Flooding Addendum  
Euroley Poultry Production Complex  
Euroley, NSW

Report Number 610.14072-FA1

20 August 2015

# Flooding Addendum

**Figure 16: Post-Development 100 year Flood Extent**  
(Source: RTS)

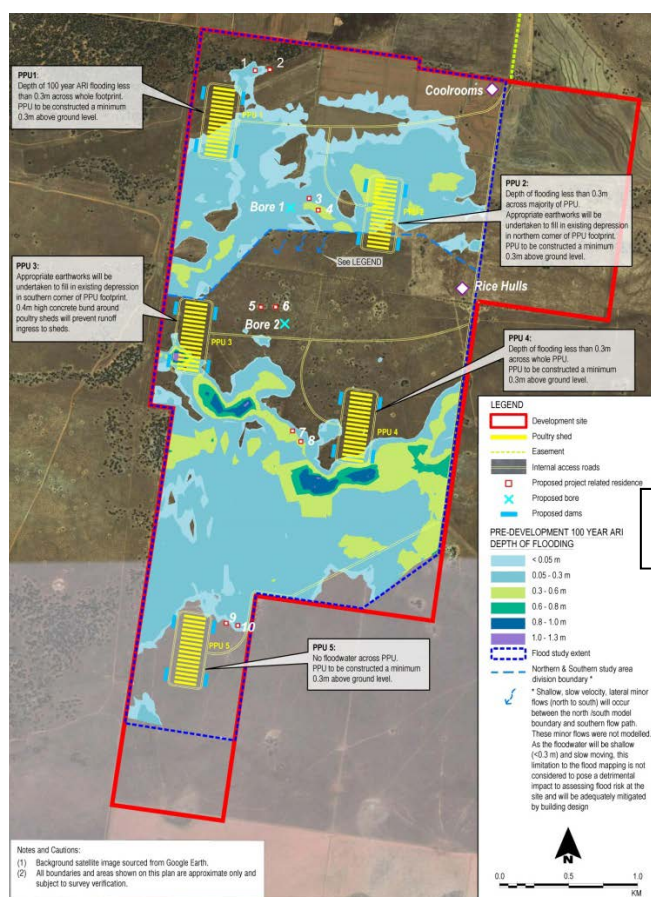
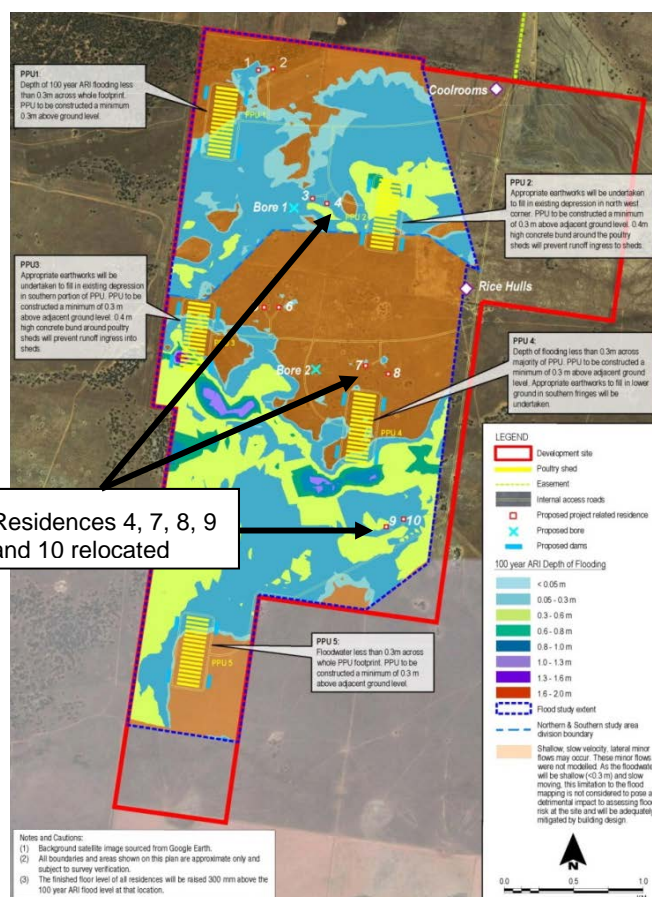
*Figure 8 (page 18) demonstrates that some of the PPUs are impacted by shallow flows. The flooding assessment provides justification of the existing planned location of the PPUs based on the assumption that construction of raised floor levels (0.3m above ground level) will provide flood immunity in the 100 year ARI event. However, Figure 8 shows the current site conditions without the presence of PPUs. There are likely to be hydraulic impacts that have not been considered if PPUs are constructed in the proposed locations. Section 4.4 of the flooding assessment (page 19), states that hydraulic impact modelling was completed and that the afflux due to the PPUs was "less than 150mm" in the 100 year ARI event. The assessment does not address the potential for inundation of PPU floors due to these results. In a situation where the PPU floor level is 0.3 m above ground level and the "pre-development" flood levels are around 0.3 m, any impediment to this flow (such as presence of a PPU) that would cause an associated afflux could potentially result in inundation of the PPU.*

*OEH understands that the proposed site layout includes a minimum distance of 1000 metres between PPUs to reduce the risk of disease transmission between units (EIS Section 3.2, page 23). This design constraint appears to be restricting the ability of the proponent to consider the flooding impacts when locating the PPUs and to select more appropriate locations away from natural drainage lines. PPUs 1 and 3 would be less susceptible to potential flooding impacts if located to the east of their proposed location, PPU 4 to the north and PPU 2 to the south. Altering the proposed location of PPU 5 has reduced the threat from flooding to that unit, however the proposed access road. Greater consideration of flooding impacts could also be applied to the location of residences, particularly 4, 7 and 8 (shown on EIS Figure 6.7, page 96), which are proposed in areas prone to flooding.*

Comments in relation to PPU construction are provided in **Figure 5**. The raising of the PPU pad level a minimum of 300 mm above adjacent ground level, infilling works at PPU2, PPU3 and PPU4 and the 400 mm high concrete bund around the poultry sheds will adequately protect the poultry sheds from flooding during a 100 year ARI event.

The PPU locations have remained unchanged as the proposed site layout includes a minimum distance of 1000 metres between PPUs to reduce the risk of disease transmission between units. This design constraint has prevented the location of the PPU2 and PPU3 from being relocated to less flood impacted areas..

Residences 4, 7, 8, 9 and 10 have been relocated and are now located within shallow flood depth zones (<300 mm deep).
